Proposal: Discharge of condition 2 (phasing plan) of 14/01932/OUT

The Phasing statement dated October 2020 and its accompanying phasing plans L&Q002-003 Rev B, L&Q002-002 Rev G, L&Q002-004 Rev D and L&Q002-005 Rev D submitted with this application.

Phasing Plan Condition 2 - Earthworks Plan

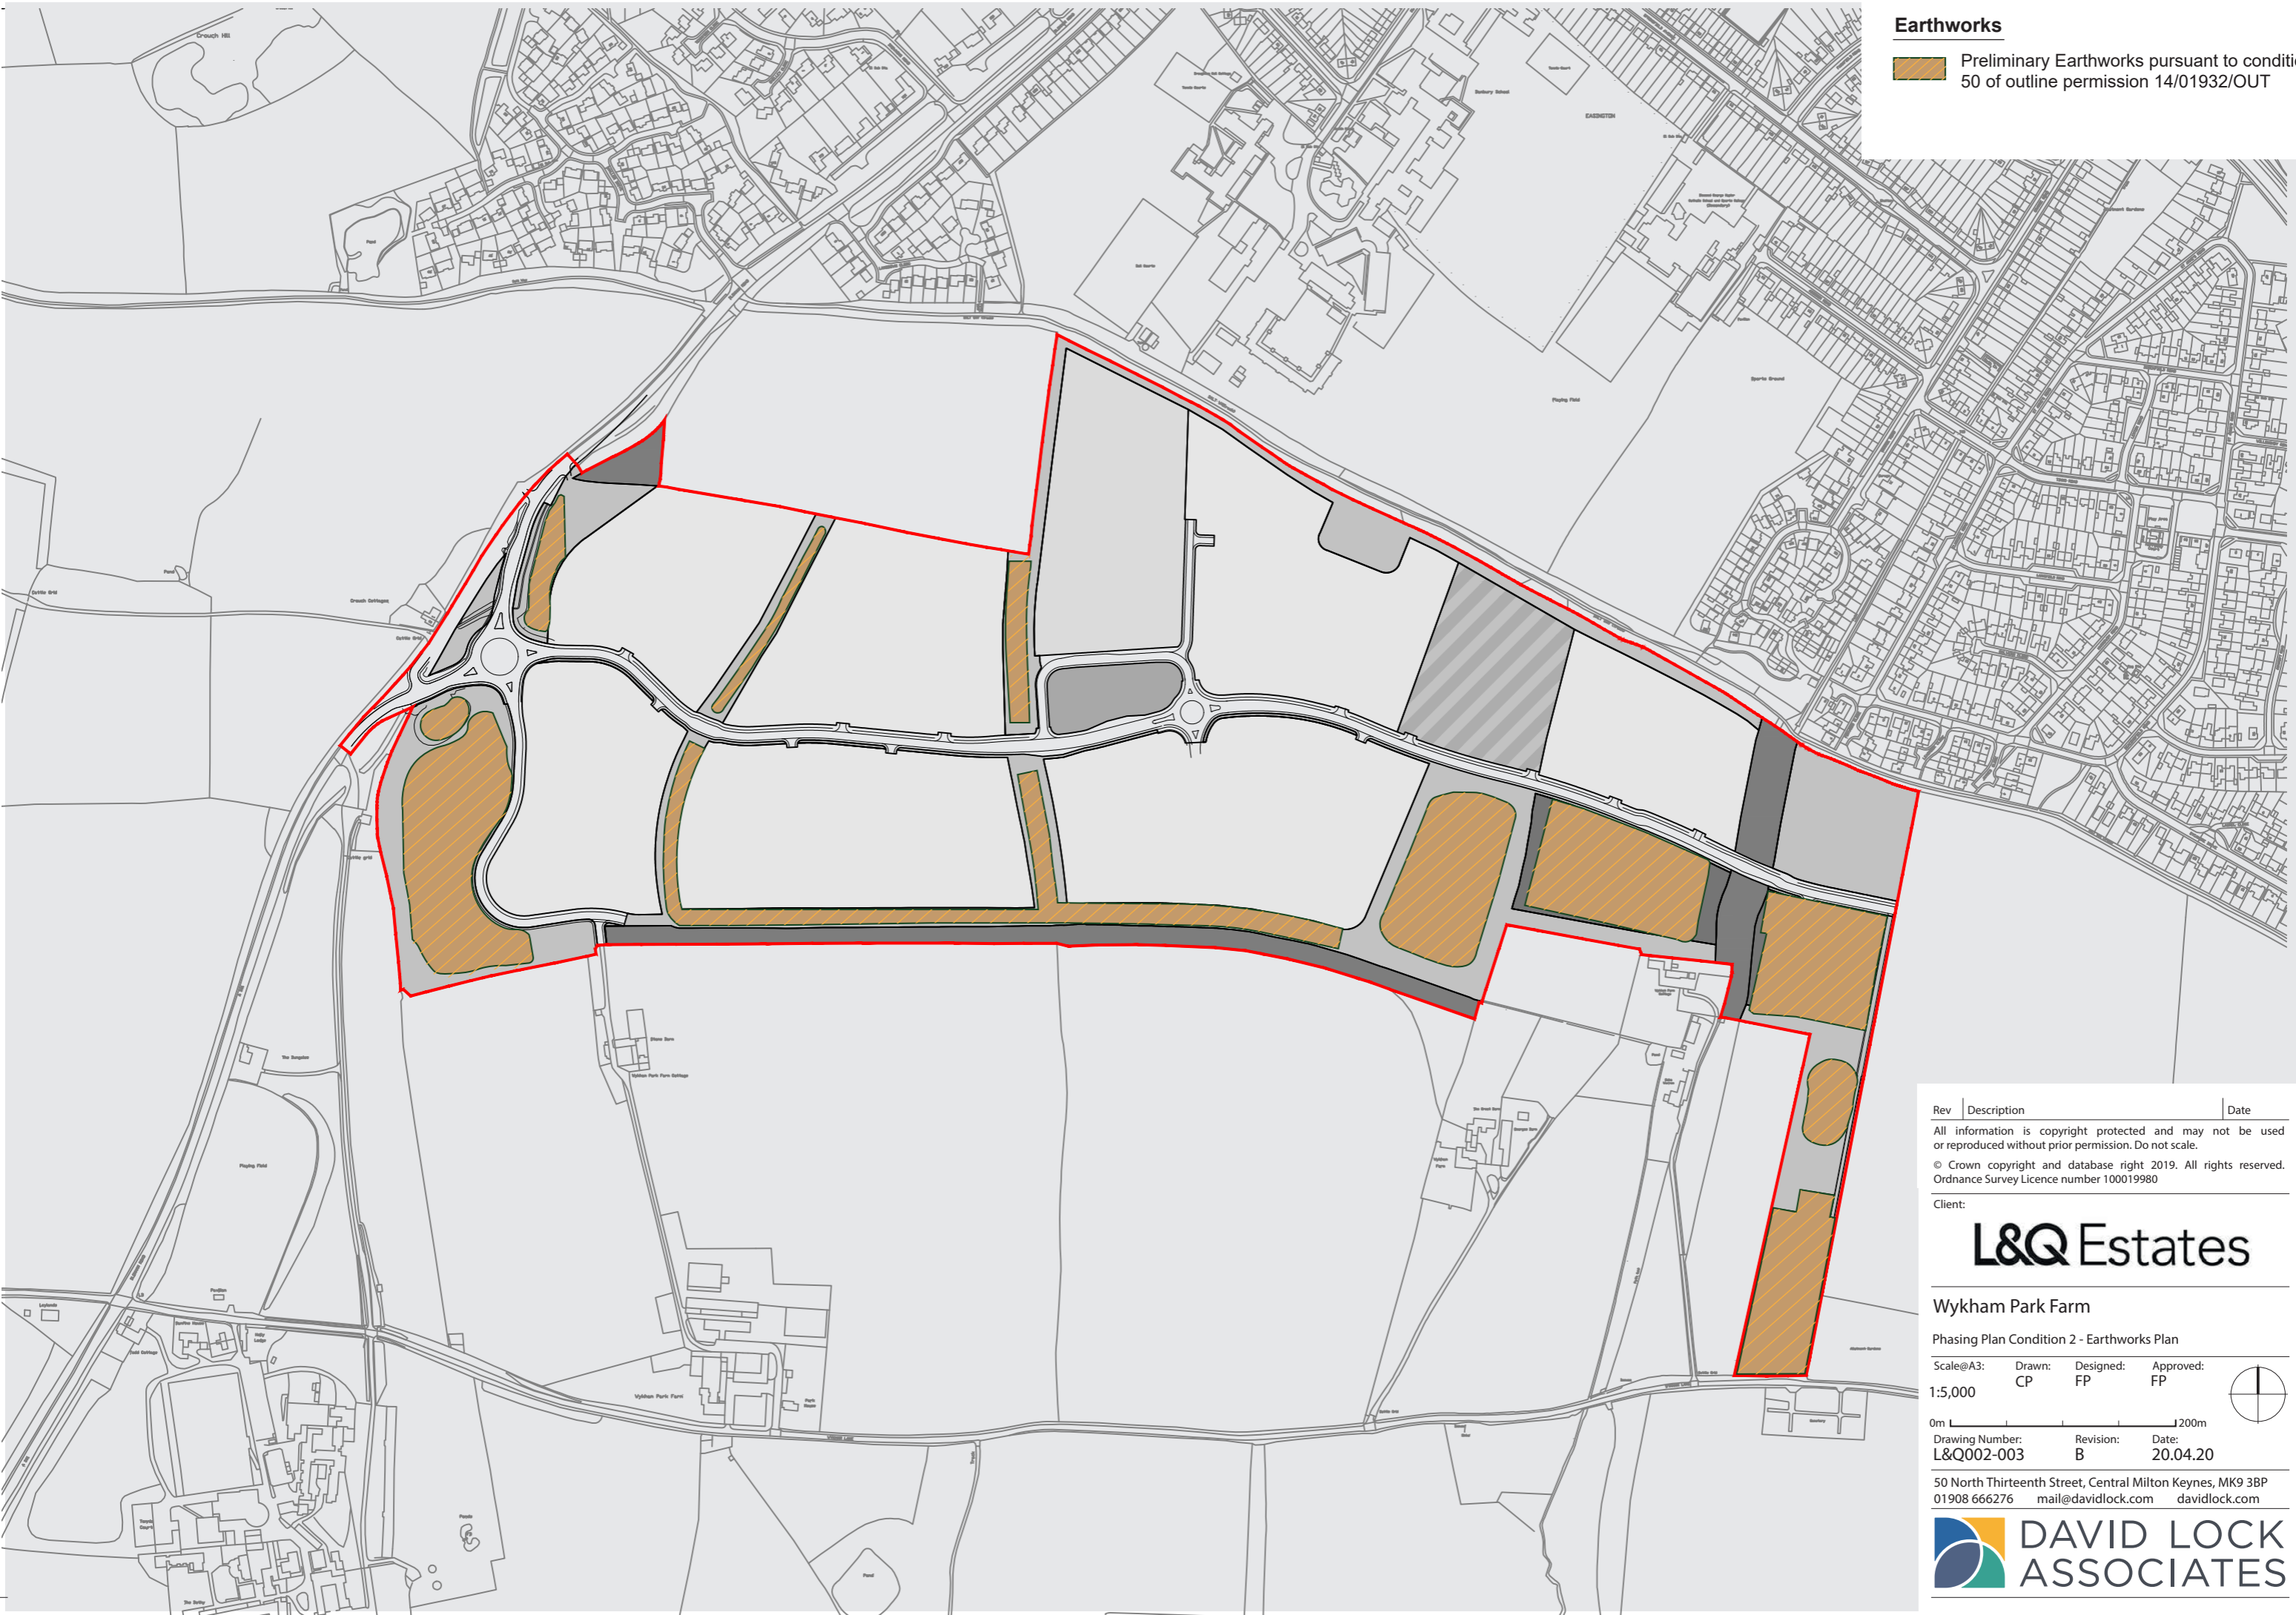
5.2. Landscape Services – I agree with the order of the proposed phasing of the landscaping but there is no indication of how this fits into the development of the housing parcels. Ideally the landscaping should be put in as advanced planting especially the first section adjacent to Bloxham Road.

Update: comments to revised phasing statement received 14th July 2020. It would be good to see the associated landscaping on Bloxham Road completed in the first planting season after the new roundabout access from A361 is installed rather than occupation of 100 dwellings.

5.4. OCC Transport – Objection. Does not cover the phasing of pedestrian links including to Salt Way. Does not include the number of dwellings within each phase. Individual phases are very large and the application refers to future sub-phases. Does not tie in the order of the phasing of infrastructure to development parcels. Incorrect assumptions regarding S106 requirements for timing of spine road in the covering letter.

Update: comments received to revised phasing plan and statement received 15th October 2020 – most of points raised in August have been addressed however a temporary hard surfaced car park should be provided prior to opening the primary school and there is no mention of the construction access.

8. Following further amendments and discussions, a revised phasing statement and accompanying plans was received in October 2020. OCC as highway authority raised further concerns regarding the provision of a temporary car park for the primary school and the timing of the construction access. The agent has responded to these comments advising that the provision of a temporary hardstanding to support the primary school is not something that has been required through the s.106, but was added to the phasing plan following OCC's initial consultation response as something they would be willing to provide but sequenced with the trigger for the community centre within the local centre. This is accepted. In terms of the construction access, this is dealt with through original condition 48.

9. In terms of the landscaping to Bloxham Road, whilst its provision as early as possible would be preferable, the proposal that it is provided prior to 100 occupations is accepted.
